Planning Application: Seeking advice on an **OUTLINE** planning application for this site for 175 residential units

Reference: A/99/17/OUT (3) **Current Comments in red typeface**

Location: Land south of Water Lane, `

Consultant Arboriculturist

Drawing no: PJC/4656/17/A	Rev: 03	Sheet number: 2 of 3
Client and site: Gleeson Homes Land south of south of Water Lane Angmering West Sussex		
Drawing title: Tree Retention Plan		
Date drawn: 08/11/2017		
Scale: NTS		
Drawn by: OA	Checked by: NB

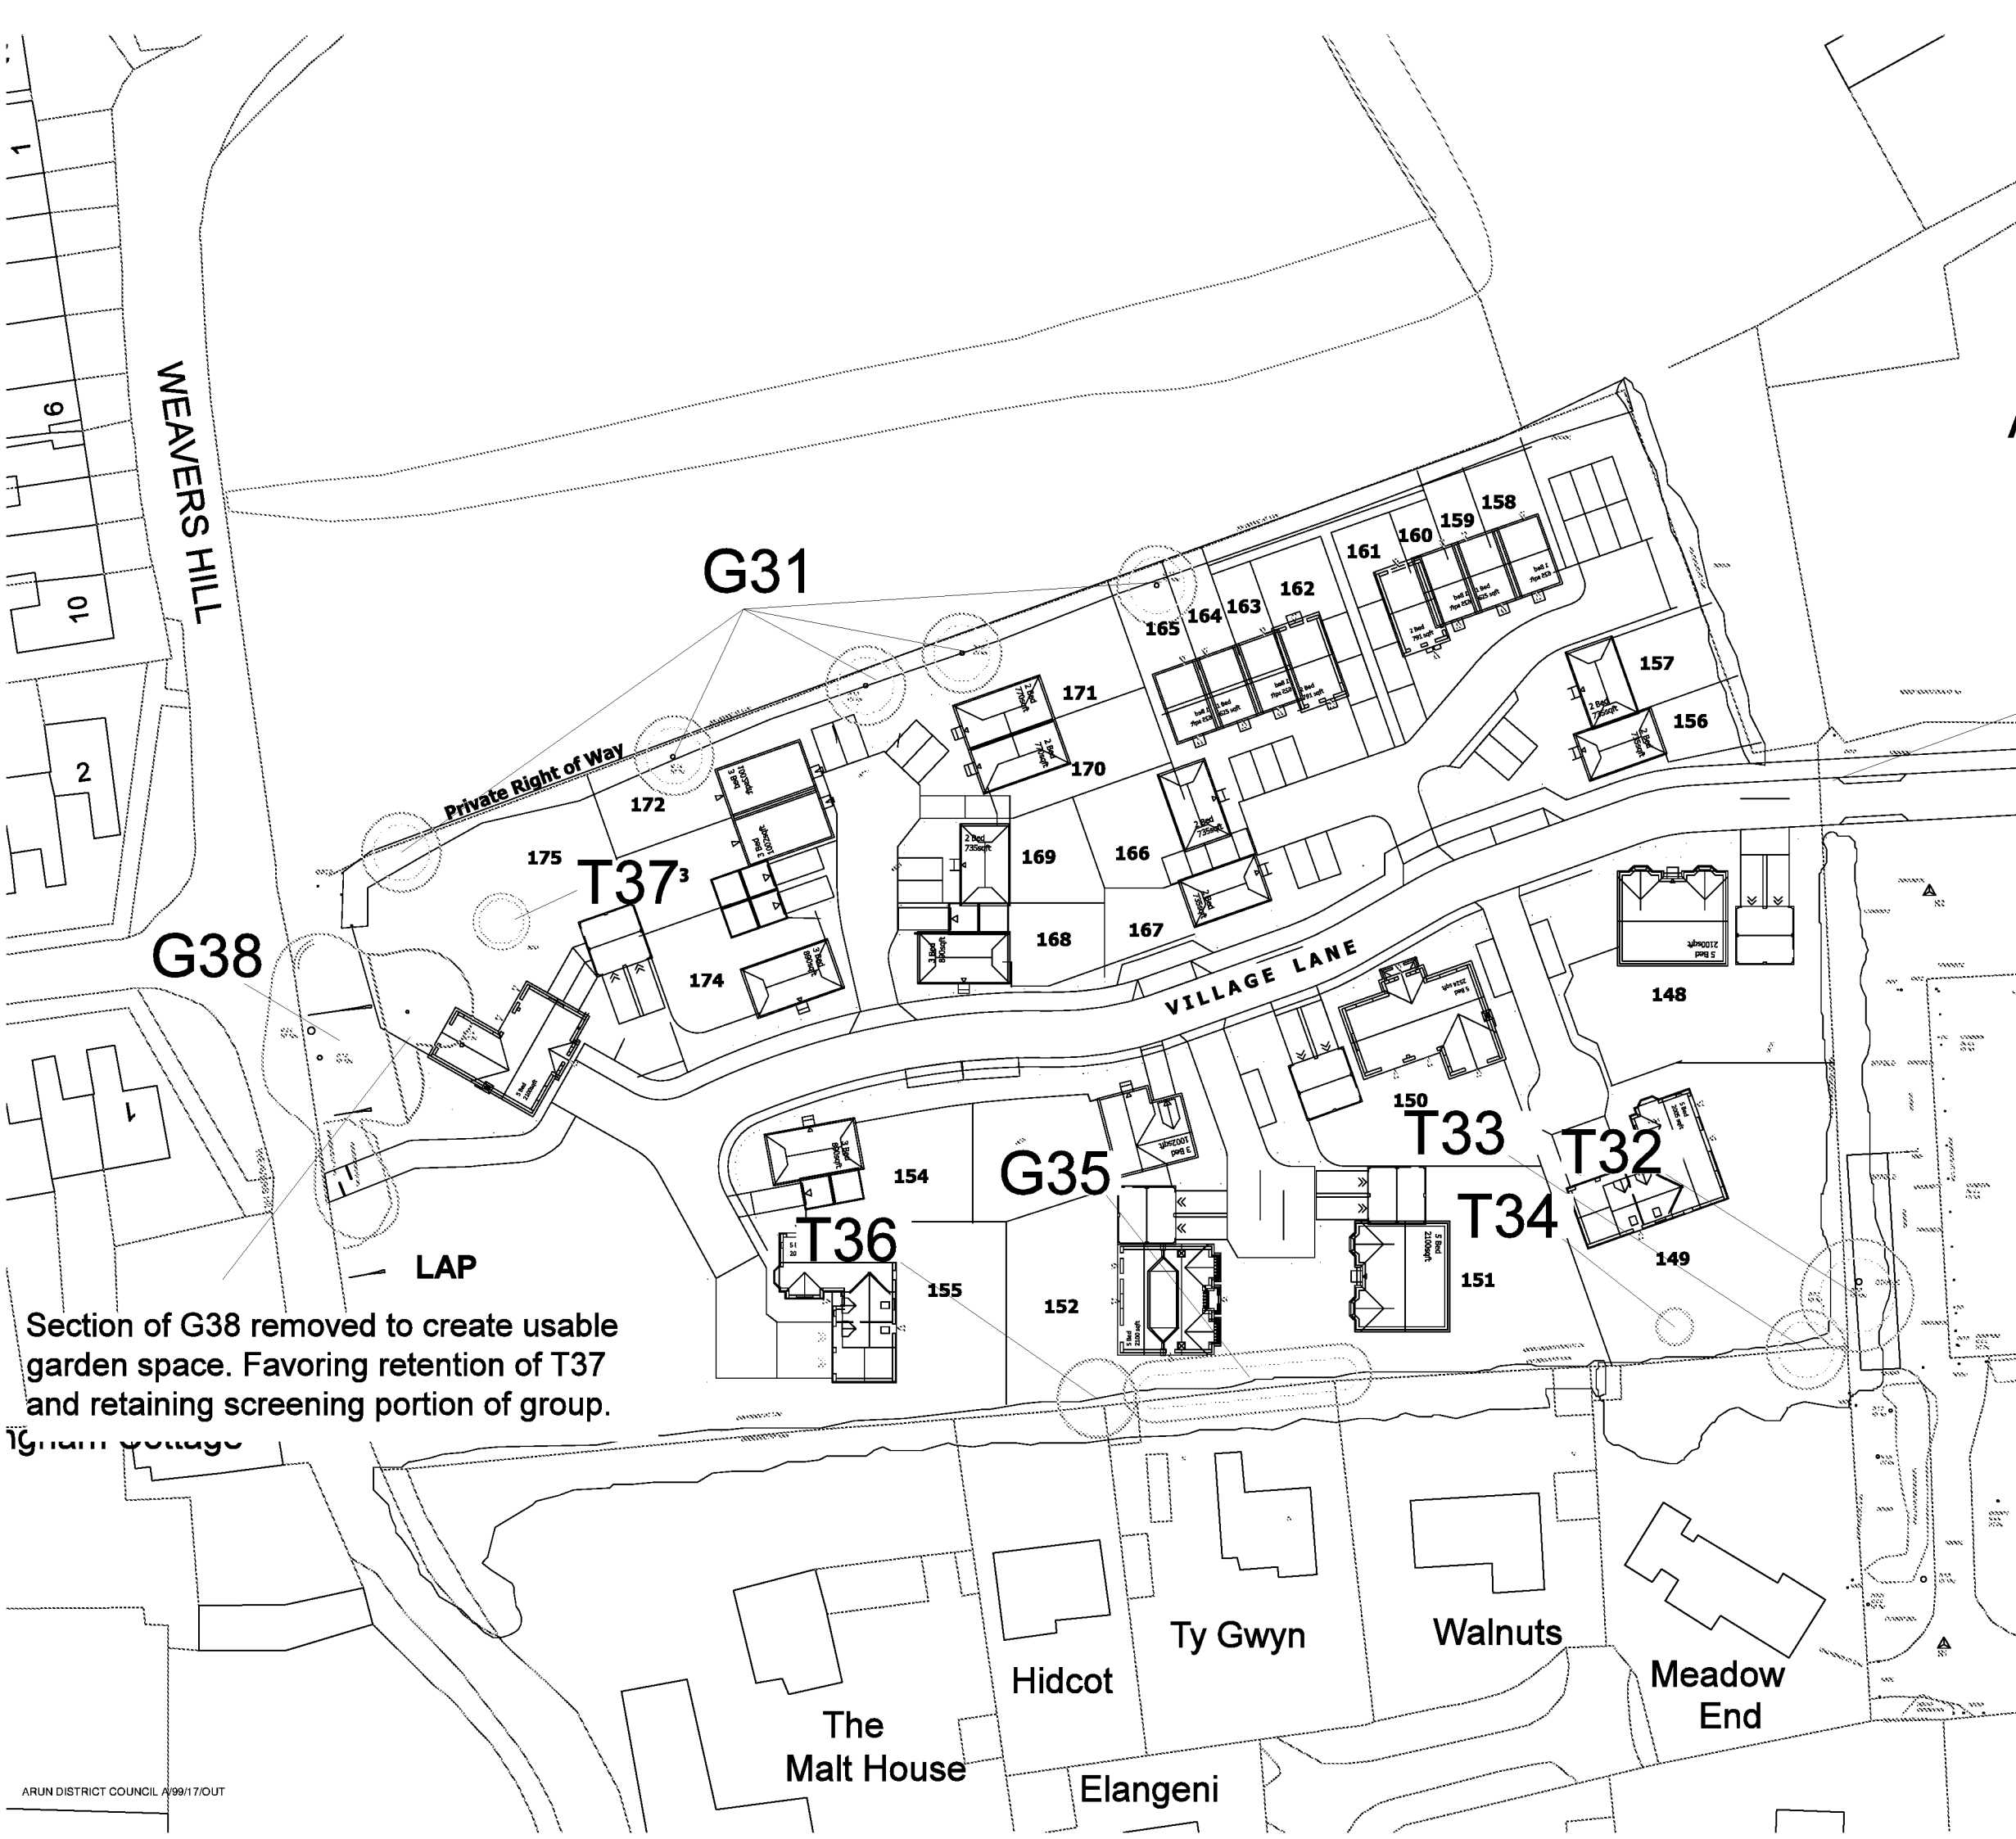
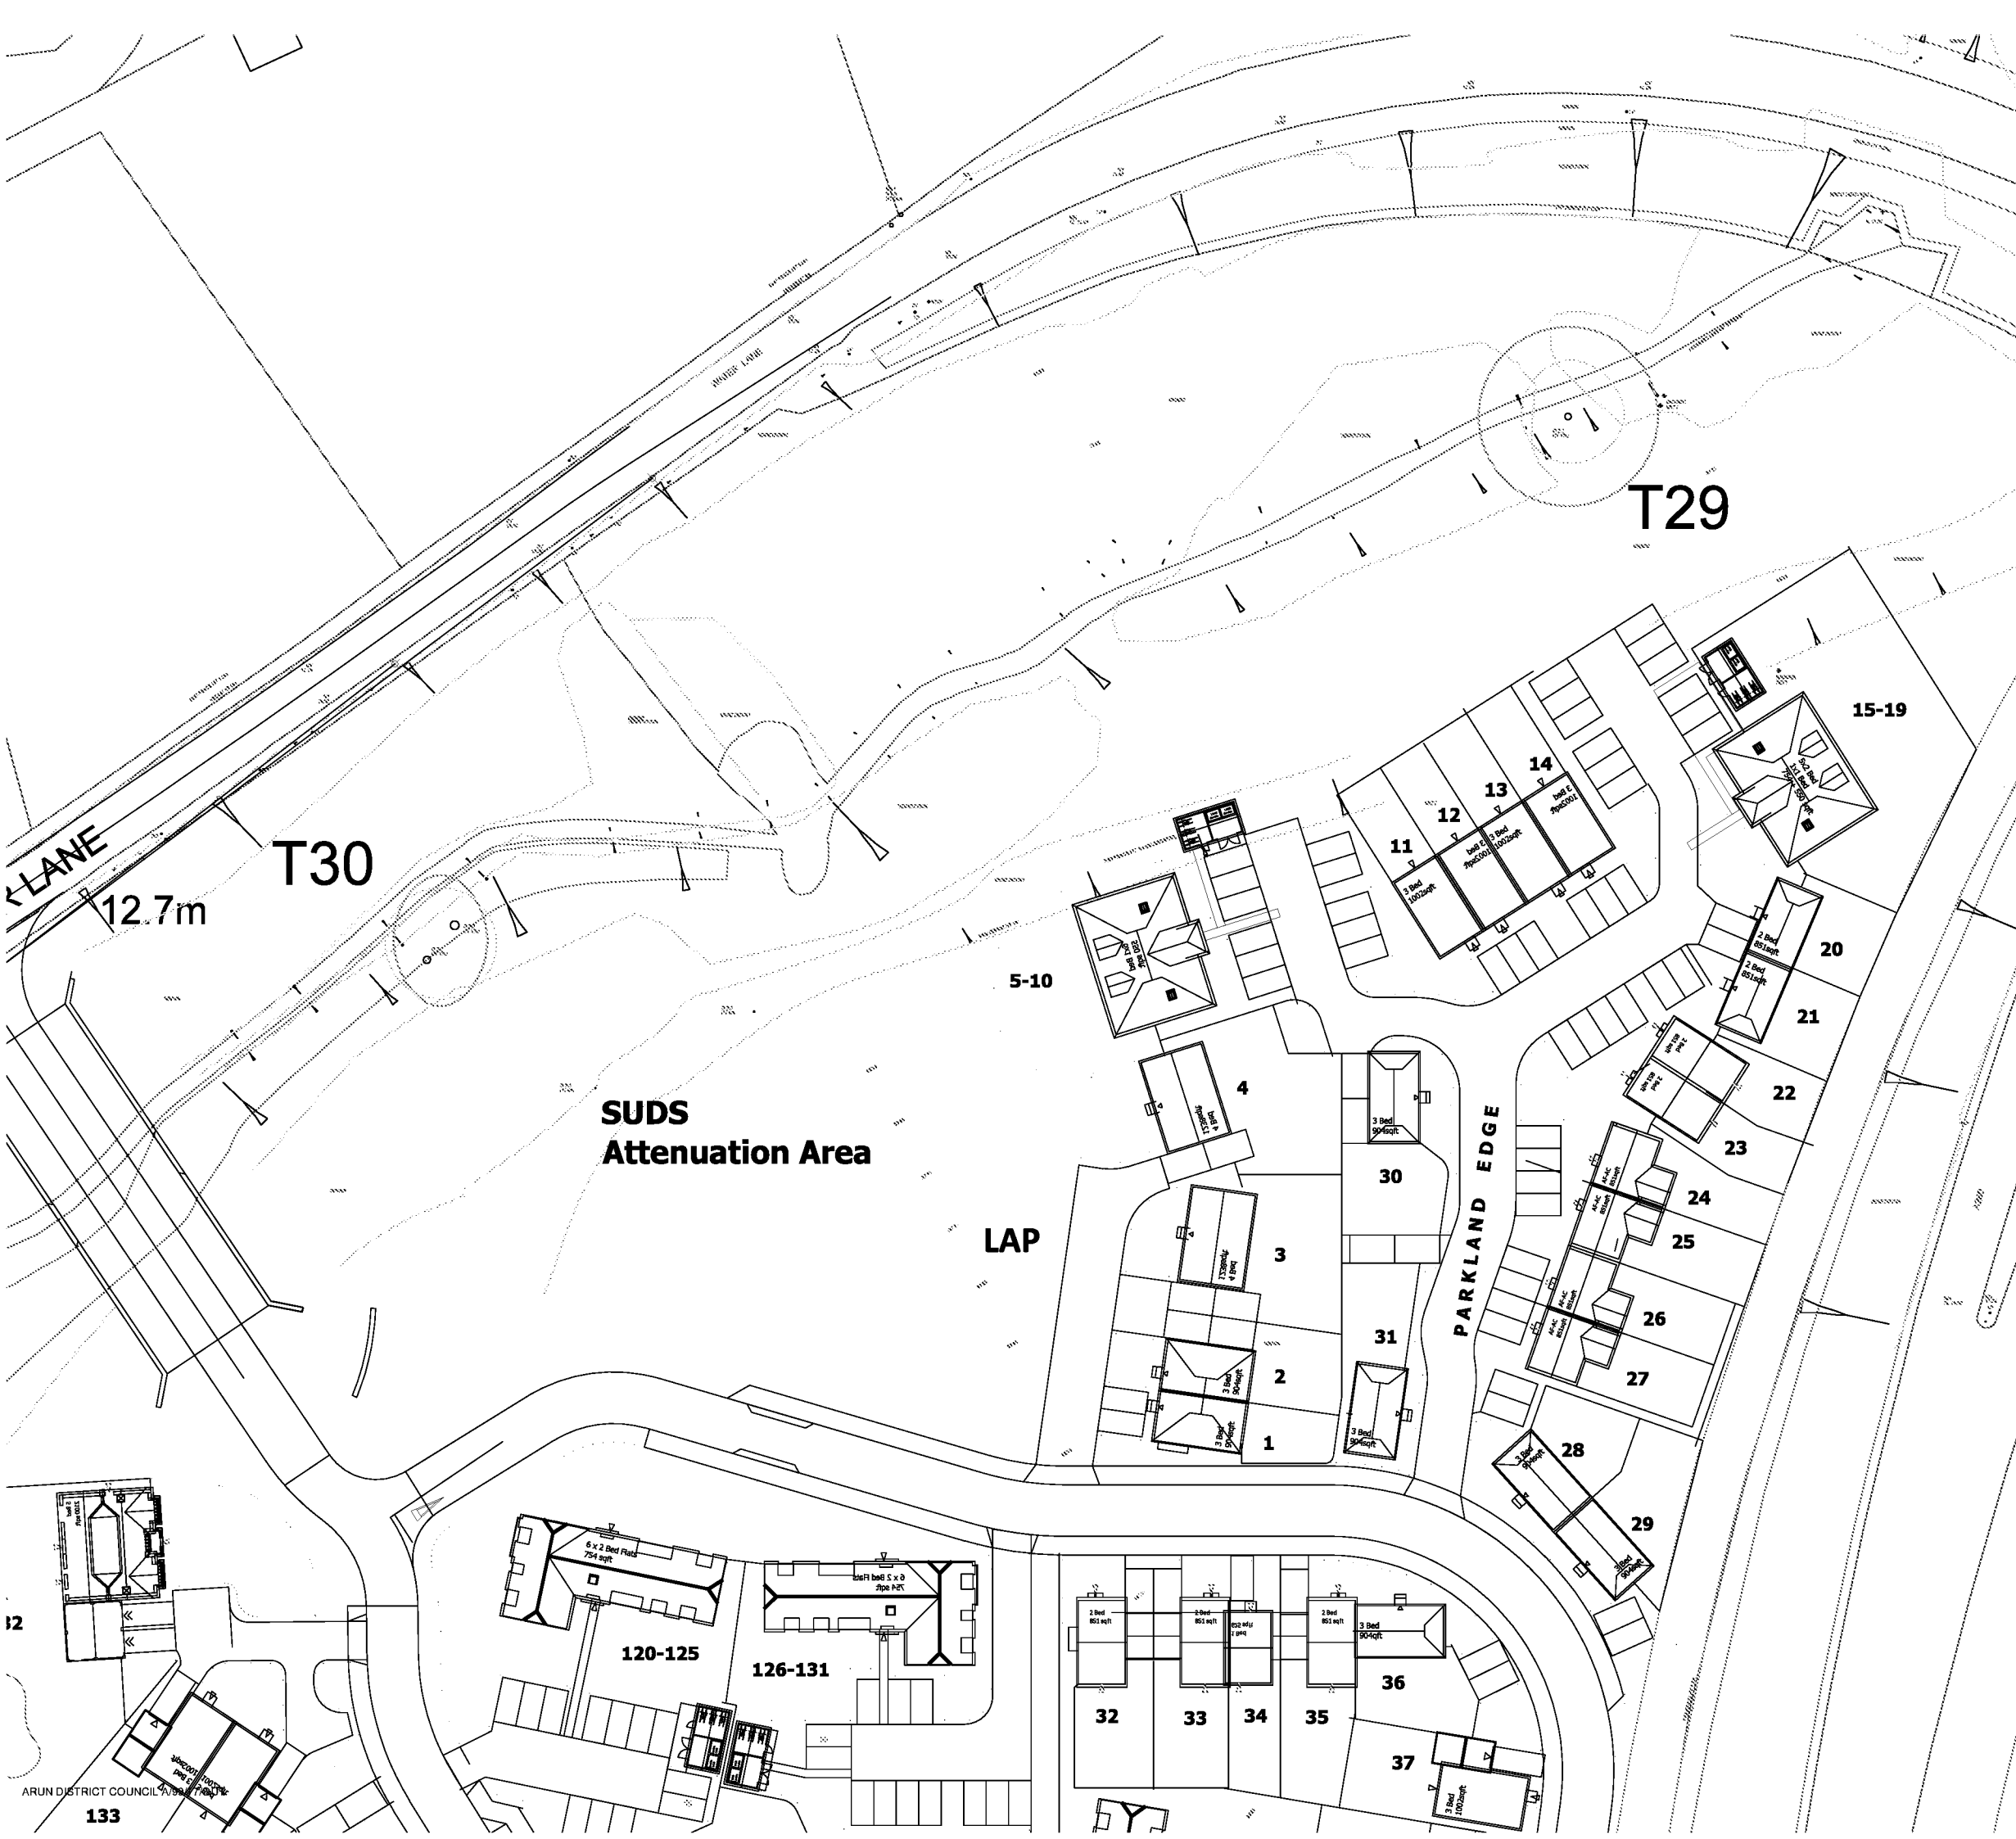
- In my review of the Illustrative Masterplan 1911/PO3 Rev E I note that in Plot 175 it shows a large garden area and no access out onto Weavers Hill and yet the PJC AIA says that it will be necessary to remove the good young specimen Oak T37 – I cannot see the justification for this!

- **We are now on Illustrative Masterplan 1911/PO3 Rev E and Plot 175 now has a huge dwelling on it which directly threatens the future of T37 Oak (which I have recommended for a TPO) – I am not happy with this juxtaposition.**

- Plot 171 & 172 place pressure on two young Lime trees in Grp 31 and whilst I note that they suggest the removal of one of these trees the other one is proposed for retention and this would be under immediate pressure to be 'pruned or felled' given that it is a young tree with significant growth potential for the future.

- **Nothing has changed with the new layout and these two trees (recommended for TPO) remain under pressure and I am not happy with this juxtaposition.**

- **However, whilst T37 Oak seems to have space to grow into - the Limes in G31 are still very close to the dwellings and whilst they are positioned to the north side and shading will be less of an issue they cannot achieve their full growth potential at this location otherwise they will dominate the Plots and gardens – thus we will be under pressure from day one to allow them to prune them back when new owners move in (as is happening all the time with the new development just completed that borders onto the Golf Club at Felpham).**

- **I am pleased to see that with the amended submission 1911 PO3 and AIA 4656/17-02 R2 6th Nov17 the masterplan now allows sufficient room for all of the TPO'd trees to be retained without intrusion into their RPA's thus complying with BS5837:2012.**
